A47 North Tuddenham to Easton Dualling

9.26 Non-Material DCO Changes Request

NON-MATERIAL DCO CHANGES REQUEST

Rule Number:	Rule 8
Planning Inspectorate Scheme Reference	TR010038
Application Document Reference	TR010038/EXAM/9.26
BIM Document Reference	HE551489-GTY-LSI-000-RP-TX-40018
Author:	A47 North Tuddenham to Easton Project Team, Highways England

HE551489-GTY-LSI-000-DR-CH-33009

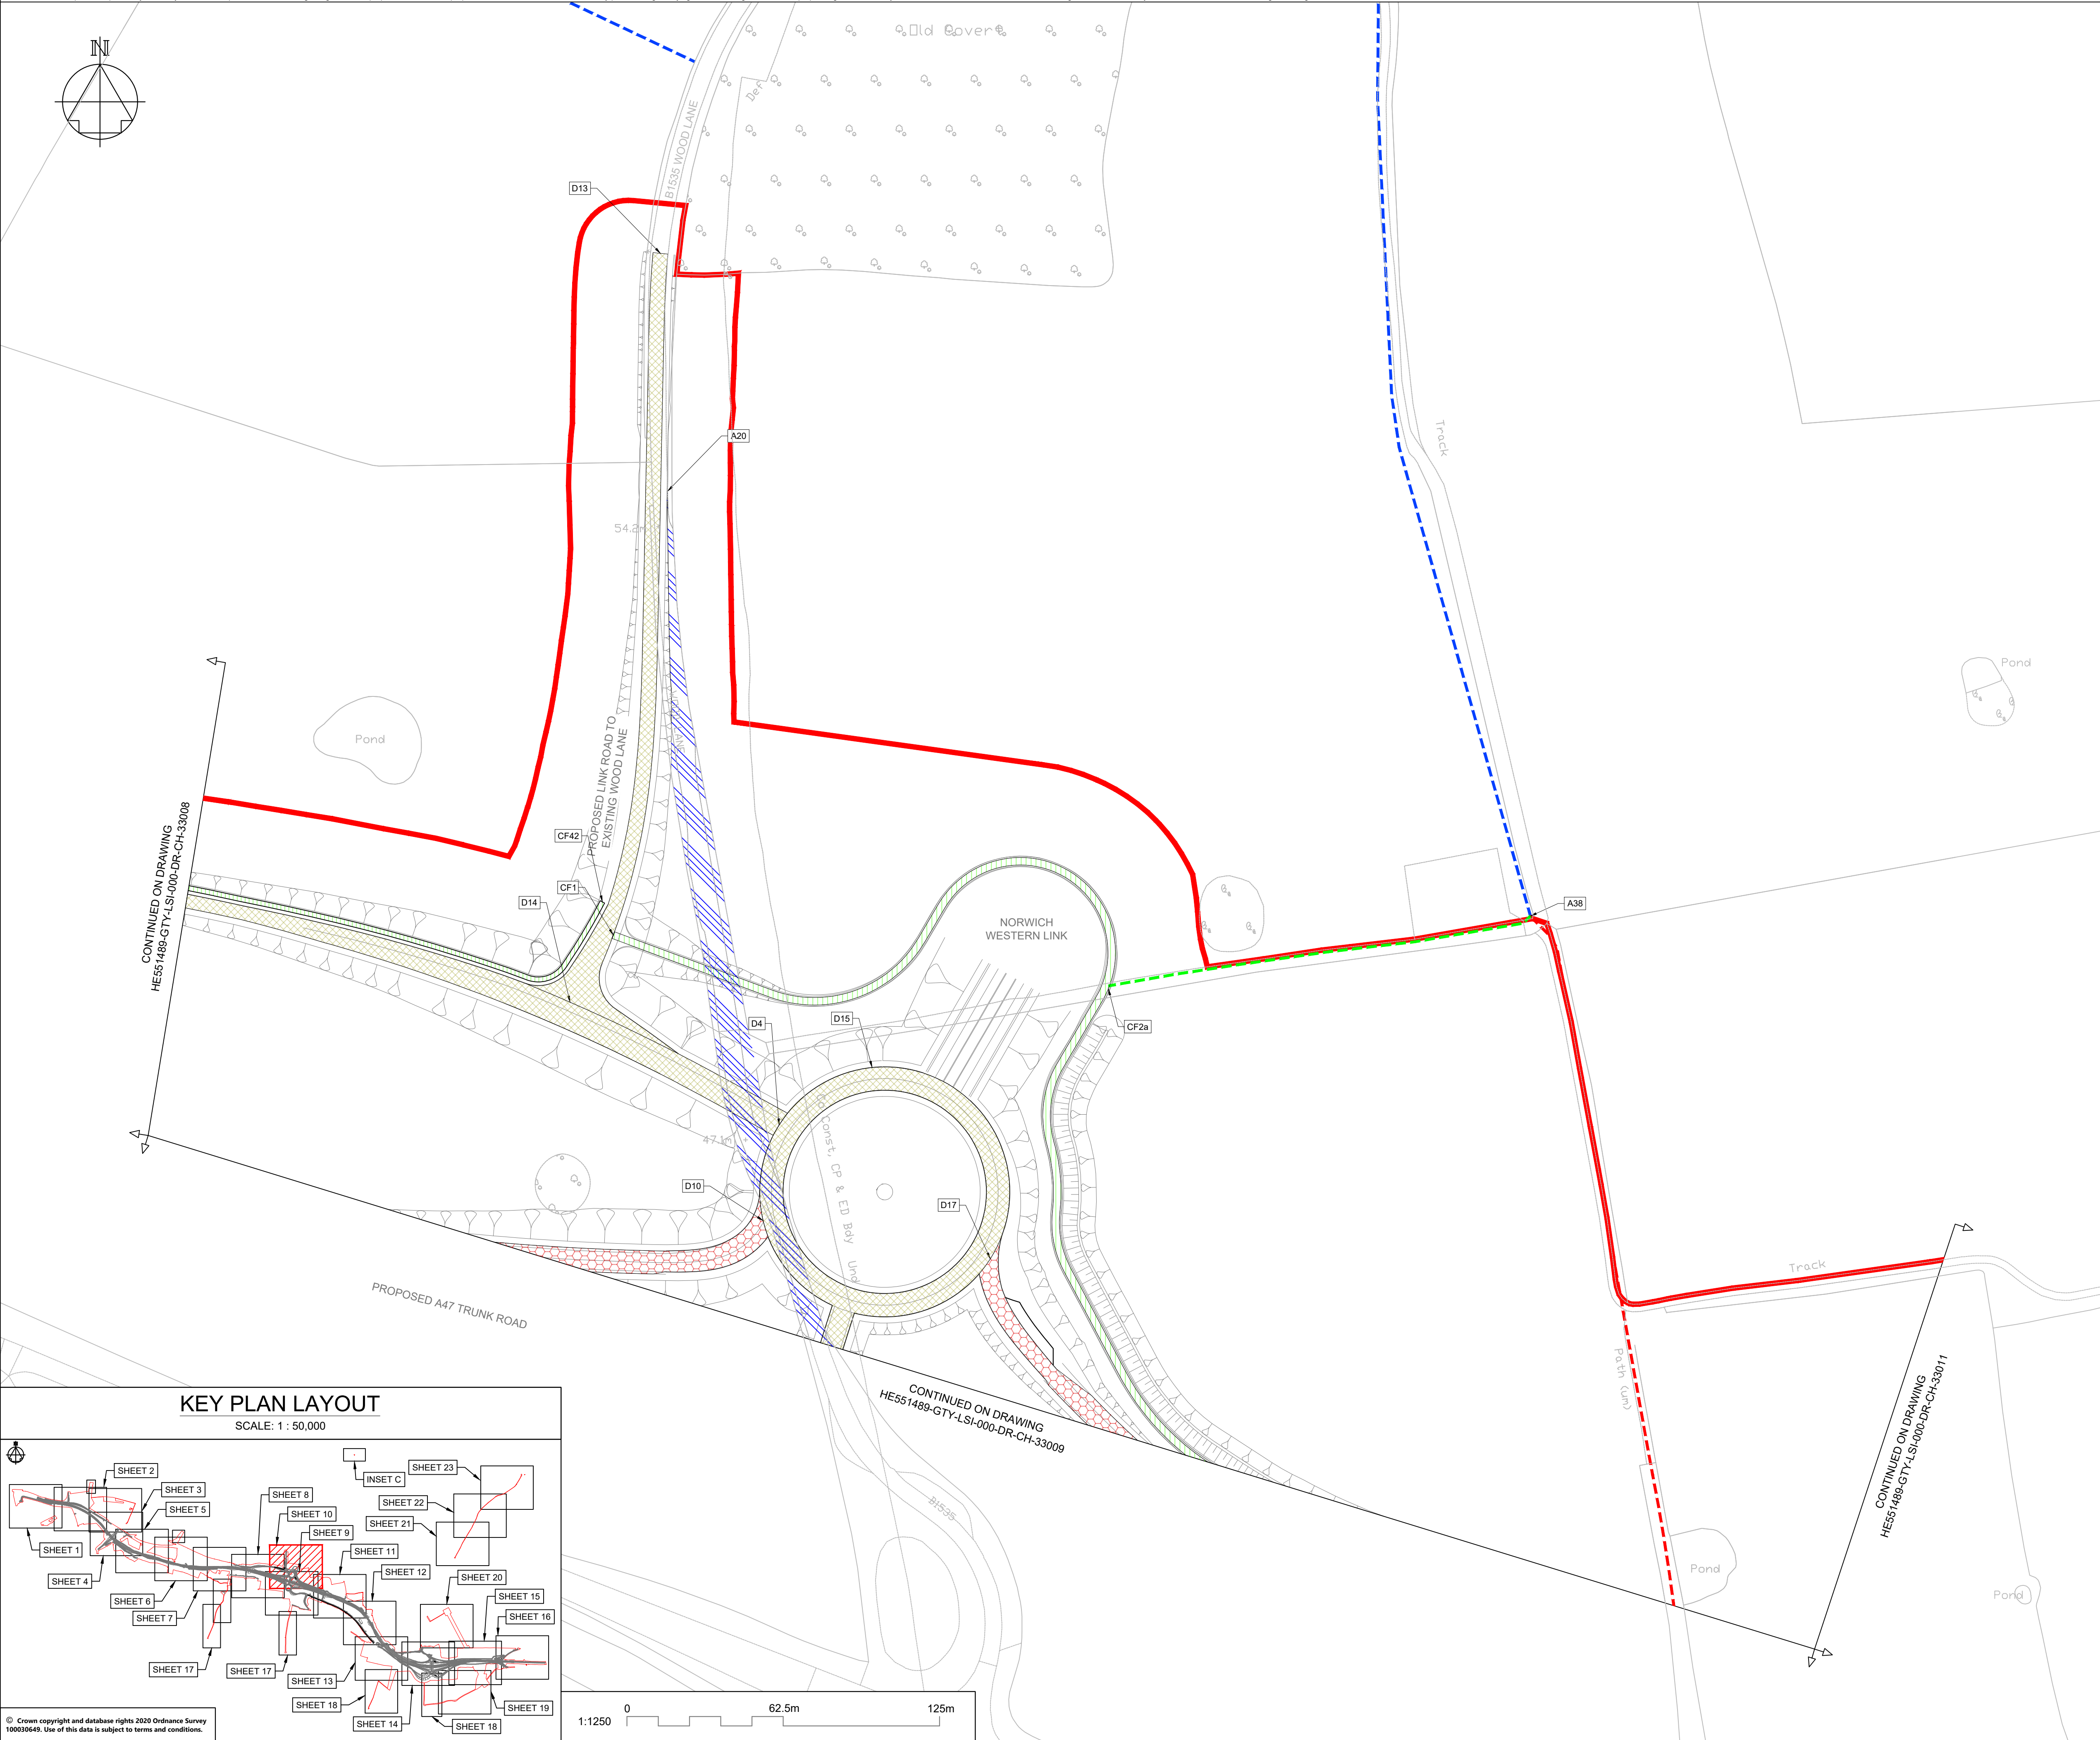
2.3.1 This design change involves the addition of a ghost island for turning right into the realigned Dereham Road (leading to Honingham) from the de-trunked A47. This design change involves the following within the existing highway limit of deviation:

- minor, localised widening of the existing A47 northwards at the junction with Dereham Road (Work No. 32)
- altering the shape of the drainage basin adjacent to the junction to reflect the northward movement of the highway's northern edge (Work No. 27), which has required the need to move the existing A47 connection to the maintenance access track 35m to the east (also Work No. 27)

2.3.2 The drainage basin change also requires a minor rerouting of the access track eastward by 35m. This improves the provision of access from the drainage basin access track to the Vodafone mast north-east of the drainage basin, between the existing and new A47 alignments.

- 2.3.4 This design change is illustrated in Figure 2.2 below and Sheet 9 of the DCO plans listed in Table 2.2 has been updated to show this slight change in the design.

- 2.4.1 This design change is to widen slightly the eastern extent of the highway limit of deviation along Berrys Lane to encompass the whole of Berrys Lane within the Order limits.

- 2.4.2 This is to allow the Applicant at the detailed design stage to continue exploring the option to tie into the existing drain on the east side of Berrys Lane, following discussions with the landowner during the Examination period. This is a non-material change to the DCO design as it would simply permit the option to tie-in to the northern end of a drainage system between the existing A47 and the River Tud.
